Environmental Impact Statement for Hume Coal Project (SSD 7172) and related Berrima Rail Project (SSD 7171): Request for Submissions

I refer to your correspondence received on 3 April 2017 requesting a submission and recommendations, if required, from the Heritage Council of NSW for the Environmental Impact Statement (EIS) for both the Hume Coal Project (SSD 7172) and the Berrima Rail Project (SSD 7171).

Mine infrastructure directly adjacent to Mereworth house and garden

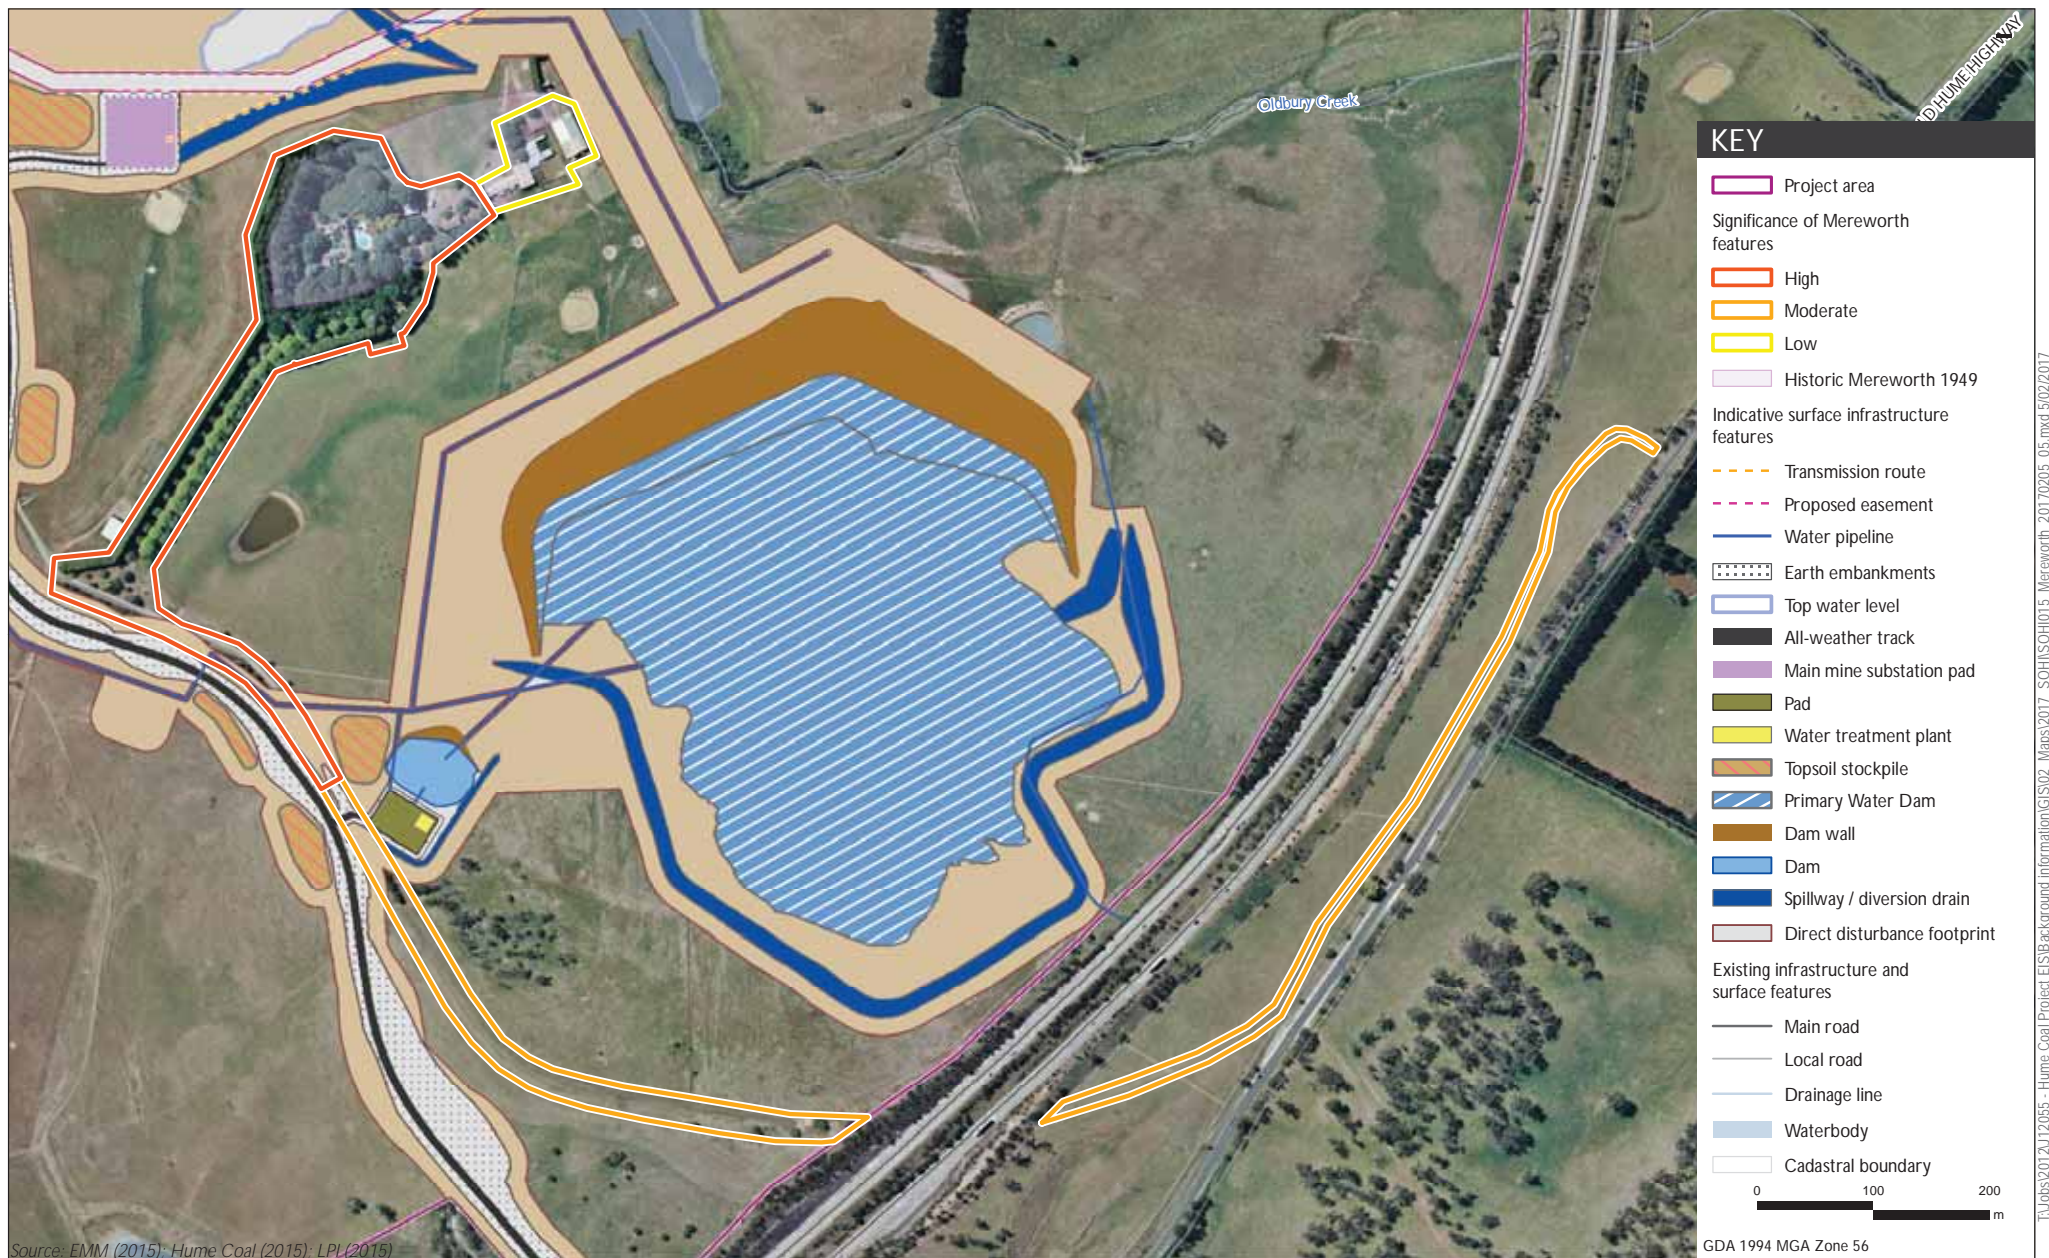
There is concern about potential adverse impact of the proposal on a key feature of Sorenson's garden design, the view to the north and east. The coal handling infrastructure, buildings, the powerlines, water infrastructure and stockpiles north of Mereworth will, for the life of the mine, has a potential to adversely impact the quality of Sorenson's garden design which borrows the long open view to the north and east. There is also insufficient information in the Statement of Heritage Impact to understand the height and size of the mine's above ground workings and structures north of Mereworth. Therefore, it is recommended that:

- **The EIS should firstly include a comparative analysis of Sorenson's design at Mereworth within his whole body of work for an up-to-date understanding of Mereworth's level of significance, ie state or local. Only then can the assessment discuss any potential impact with greater certainty and recommend effective measures to prevent a negative impact. The analysis should be undertaken by a heritage landscape consultant with demonstrated experience with similar historic landscapes. Then, based on the comparative analysis, the EIS should reassess the impact of the Hume Coal Project (SSD 7172) above ground workings in greater detail.**

- **The following three views need to be accurately rendered and presented at least at A4 size for clarity:**
 - **the view from within Sorenson's Garden out to the north and east;**

- **the view to Mereworth House and Garden from the highest point on the original Mereworth drive; and**
 - **the view to Mereworth House and Garden from the Old Hume Hwy parallel to the original drive, now disused.**

These views need to accurately illustrate the appearance, size, scale of the mine's above ground infrastructure and its proximity to the House and Garden. This is important so that the assessment of any impact is correct and negative impacts on these views can be prevented. The applicant should provide this analysis and subsequent assessment prior to determination of the application, so that it informs the conclusion of any determination.
